Demolition of 1 No. dwelling & erection of 4 No. dwellings. This application affects the character & appearance of the Station Road, East Preston Conservation Area.

St. Marys Close Hurst Road Rustington

Thank you for your internet representation made on 3rd May 2017 which has been recorded as '**an objection**' with the comments as follows:

Drg No: 151117_SS-01 Rev: D

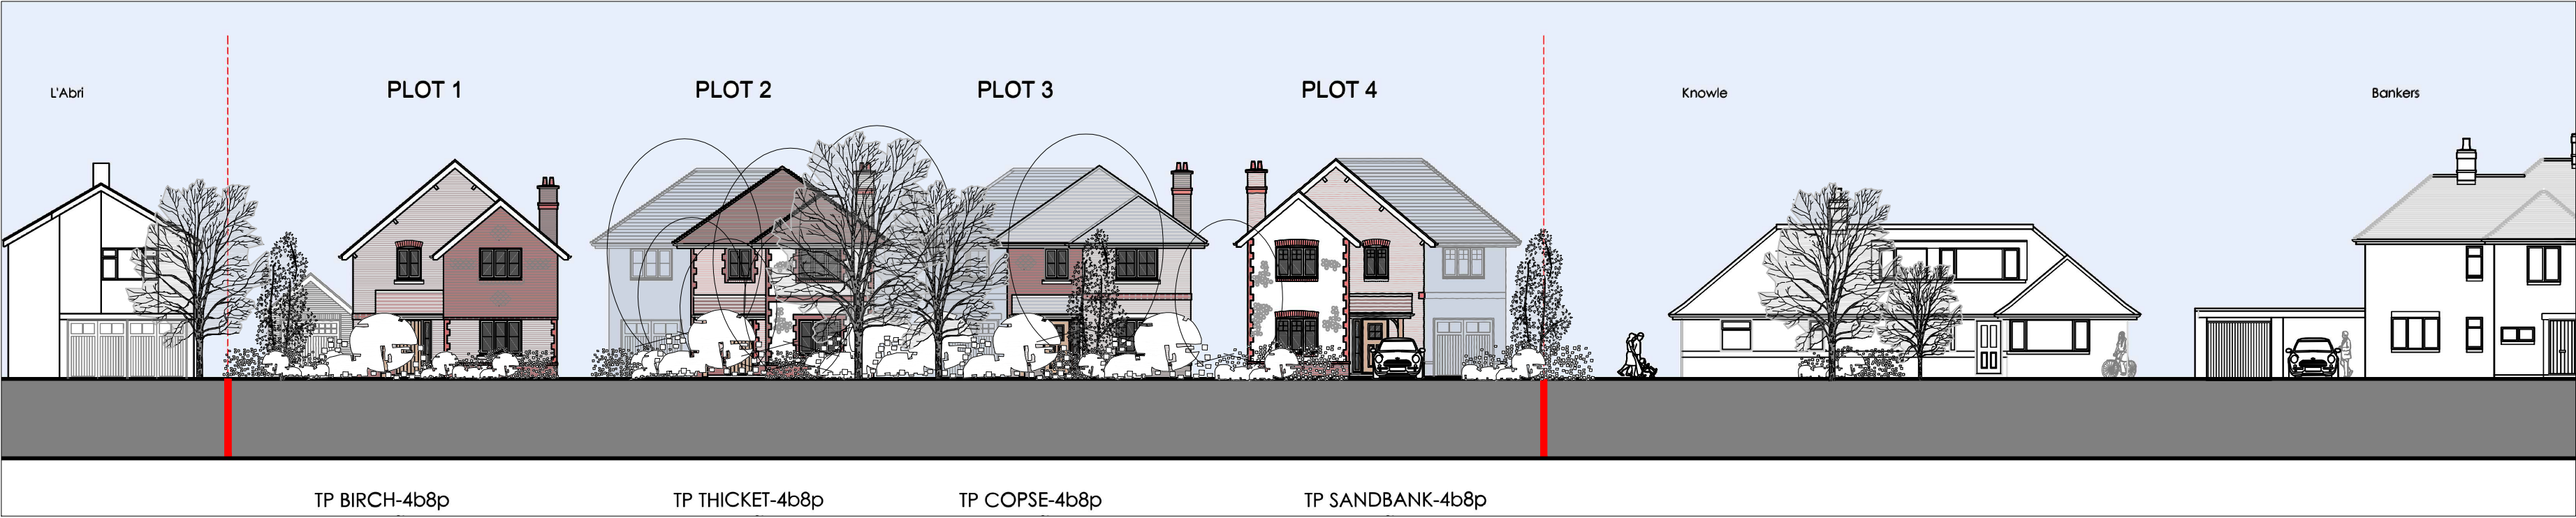
The illustrations and drawings for this proposal exaggerates the spacing between the 4 houses in a futile attempt to detract from the true impact to the street scene which is further aggravated by the erection of twin car ports to the front of houses 1 & 4 which are located way beyond the building line a feature totally alien to any dwelling on Hurst Road.
